CITY OF ALBUQUERQUE

December 2, 2011

**Re: Plastic Machine Shop Grading and Drainage Plan, 2601 Baylor SE
Engineer's Stamp Date 11-23-11 (M16/D037)**

RETENTION POND SECTION

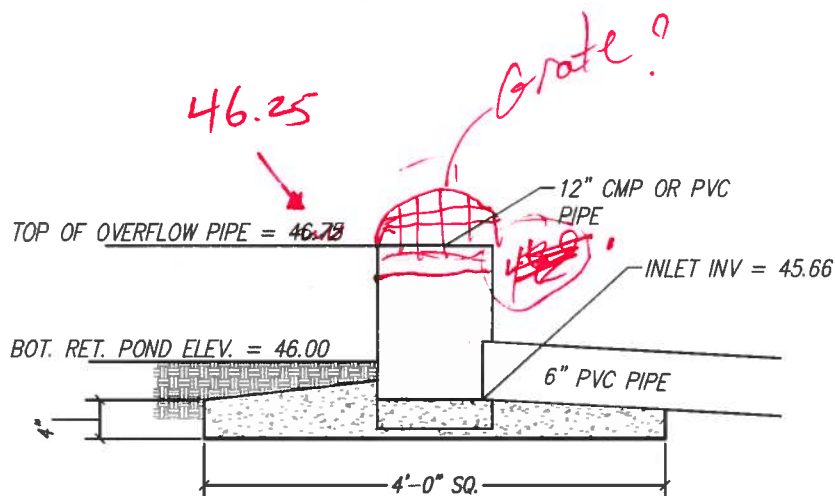
- Provided riprap at the bottom of the pond at the end of the pipe and the rundowns. Extend the rundown ripraps to the bottom of the pond.
- Provide additional spot elevations on the East and the North side of the building to assure positive drainage to the North.
